From: Jean Fraser
To: Greer, Tom
CC: Lloyd, David; Newell, Chip; Pitman, Cordelia; Sawyer, Rita; Stanley,...
Date: 4/9/2014 4:46 PM
Subject: Re: FW: revised plans

Attached is the revised Landscape plan for 118 Congress. We believe it meets the requests made by Jeff. Please let me know if you have any questions.

Here are the revised plans for the 118 project. These show the planning board conditions: revised tree selections, larger plants in the rain garden, and the 4' high fence raised to 6'.

LANDSCAPE PLAN
SCALE: 1" = 8'-0"

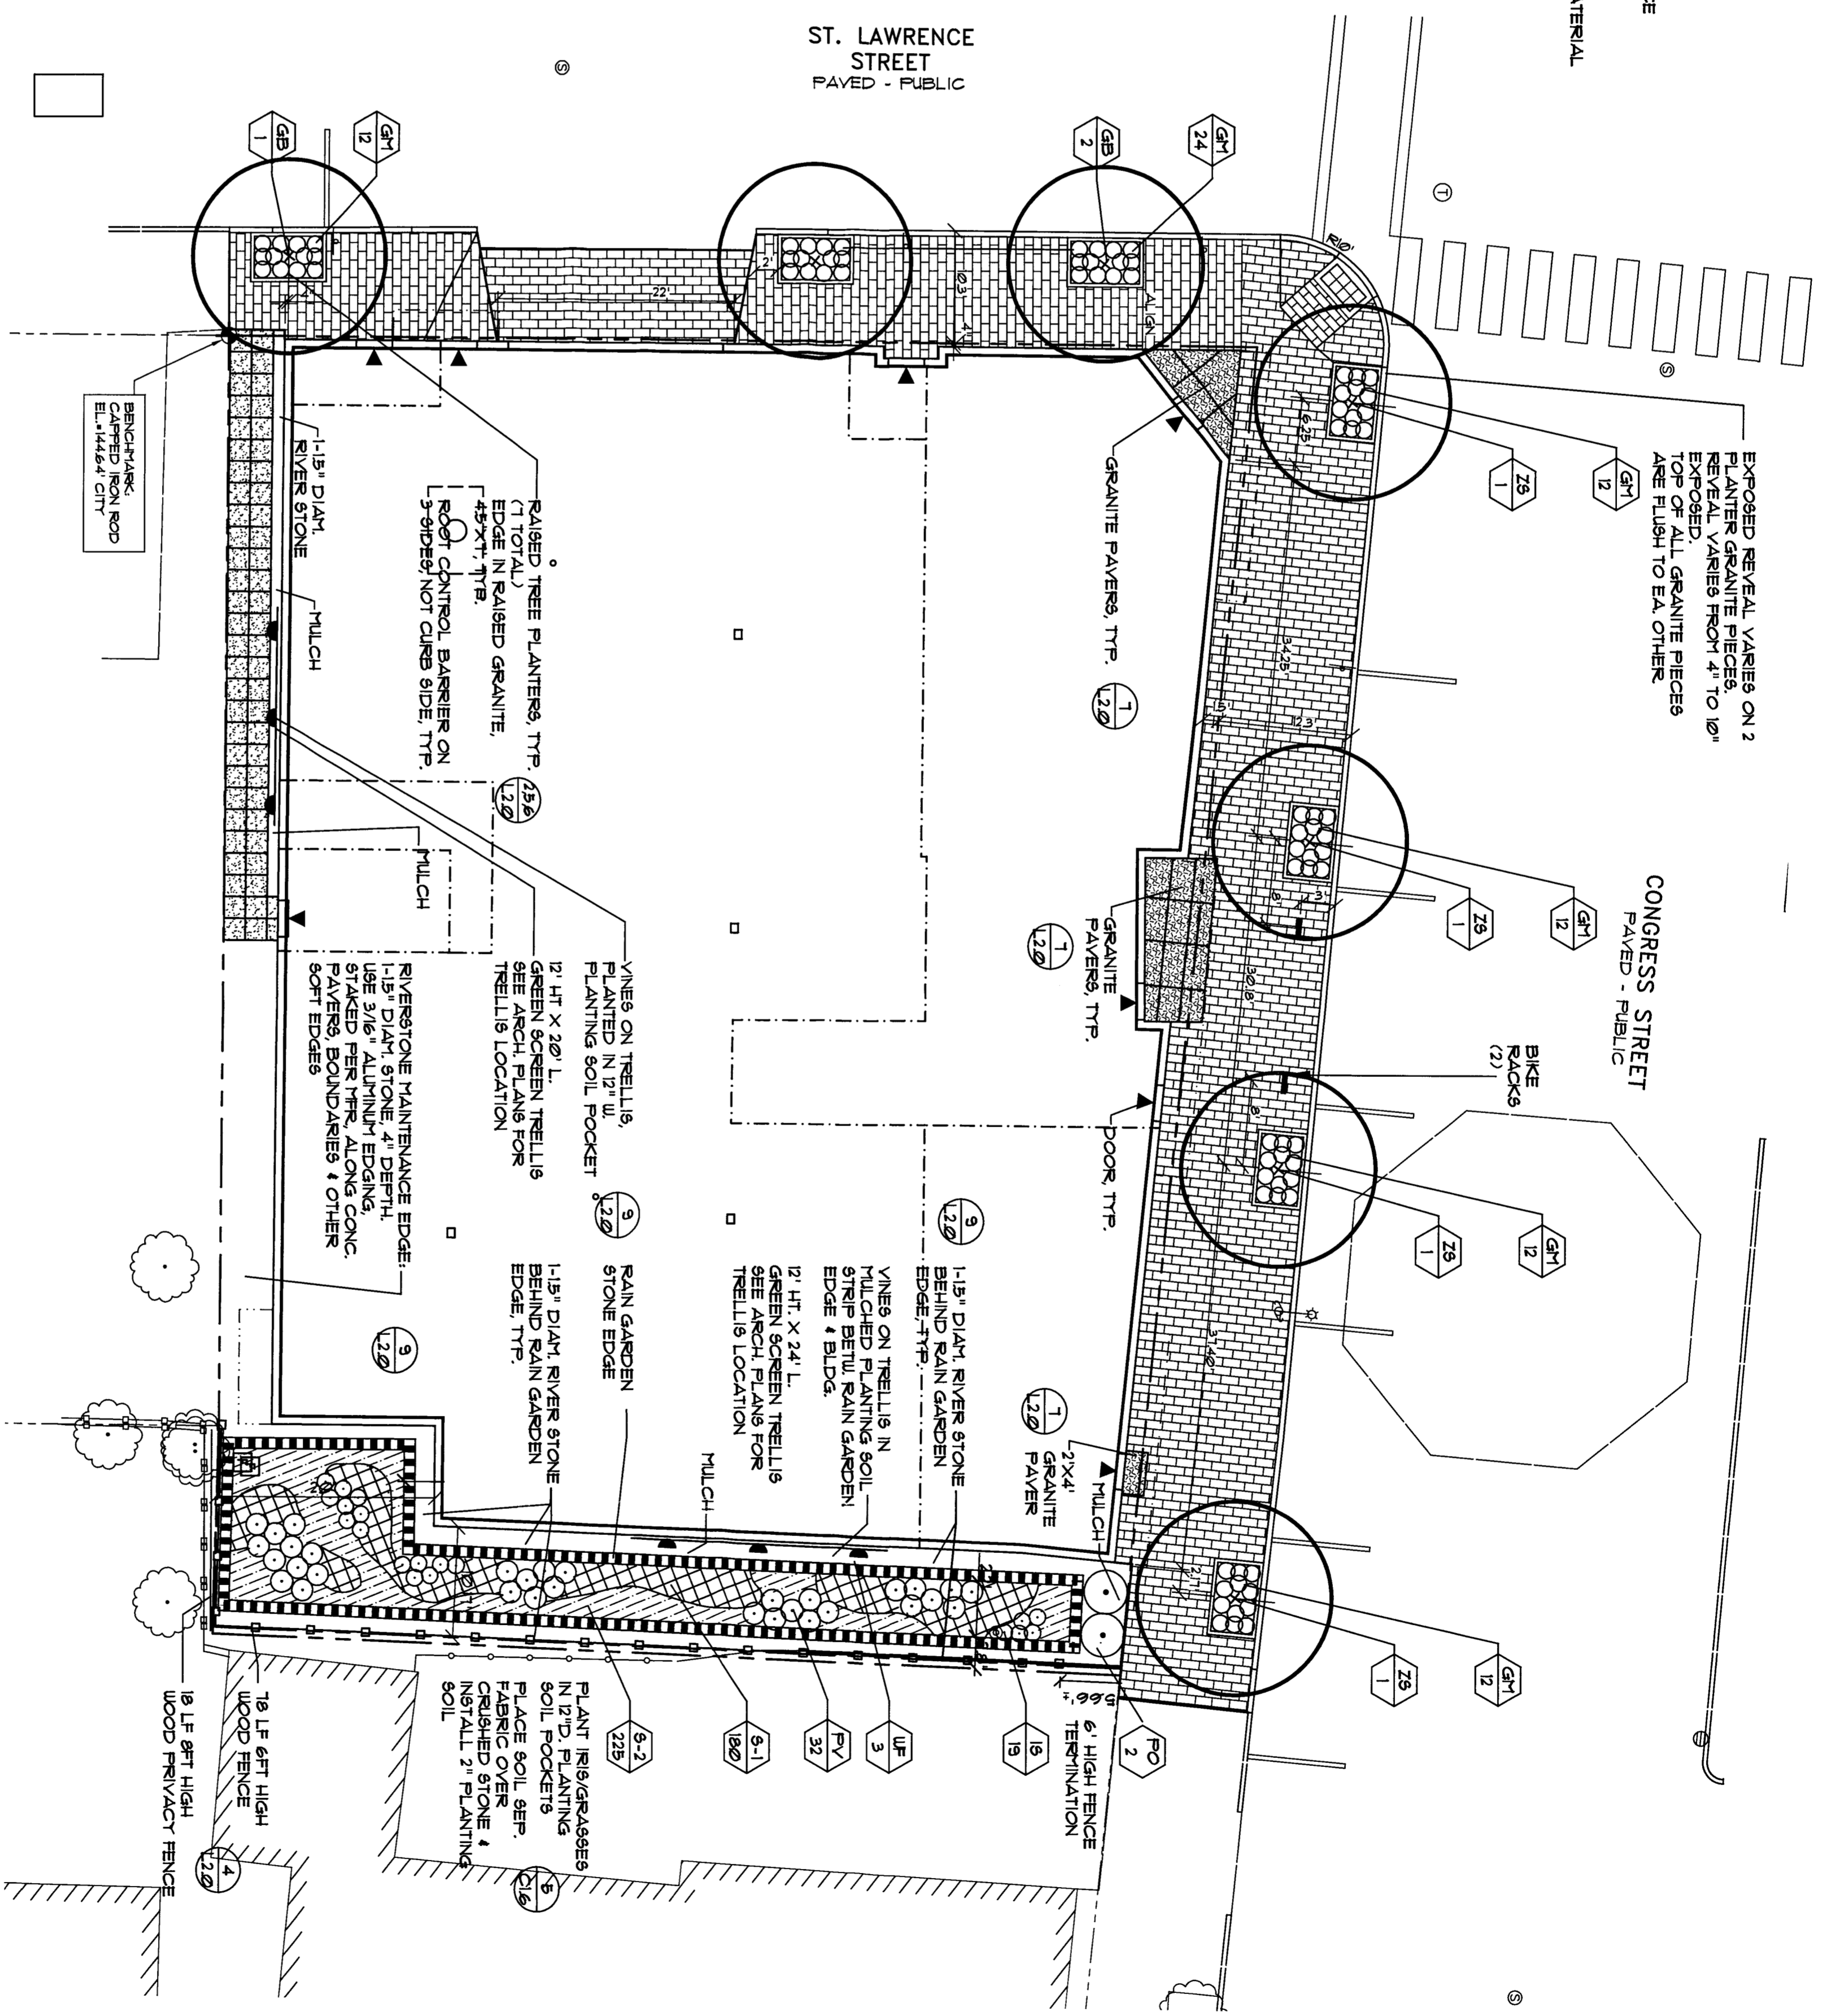
Jeff Tarling had raised a concern in his comments (as attached to the Approval letter and ref'd in the condition) that the location of the treewells for the street trees would need to be set back and carefully sited to avoid conflict with parked vehicle doors opening- especially if they are going to be raised granite and close to the curb. (The on street parking space nearest to St Lawrence is for a share car)

So could you send a plan (can be a sketch plan as long as to scale and accurate) showing both the street trees/ treewells and the approximate location of the on-street parking spaces (or parked vehicles assuming an average vehicle length) along the Congress and St Lawrence street frontage so that this question can be resolved now- as the location of the street trees is shown on the Plat and once that is recorded it potentially could mean a plat amendment if they need to be relocated (as well as other problematic implications for the area and the project). As you recall the Board were not convinced they needed to be relocated and replaced, so we would want to take all prudent steps to be sure the relocation is successful.

The same applies to the underground utilities that often result in street tree locations not working- since you have chosen to relocate the street trees, we would like confirmation that the proposed locations do not conflict with utilities- again to ensure that the locations shown on all the plans and plat are reasonably final.

Also, on the plan with the street trees/parked vehicles please show the location and tipdowns for the Congress Street crosswalk (based on latest discussions with DPS) so we can be sure the crosswalk also integrates well with the street tree locations.
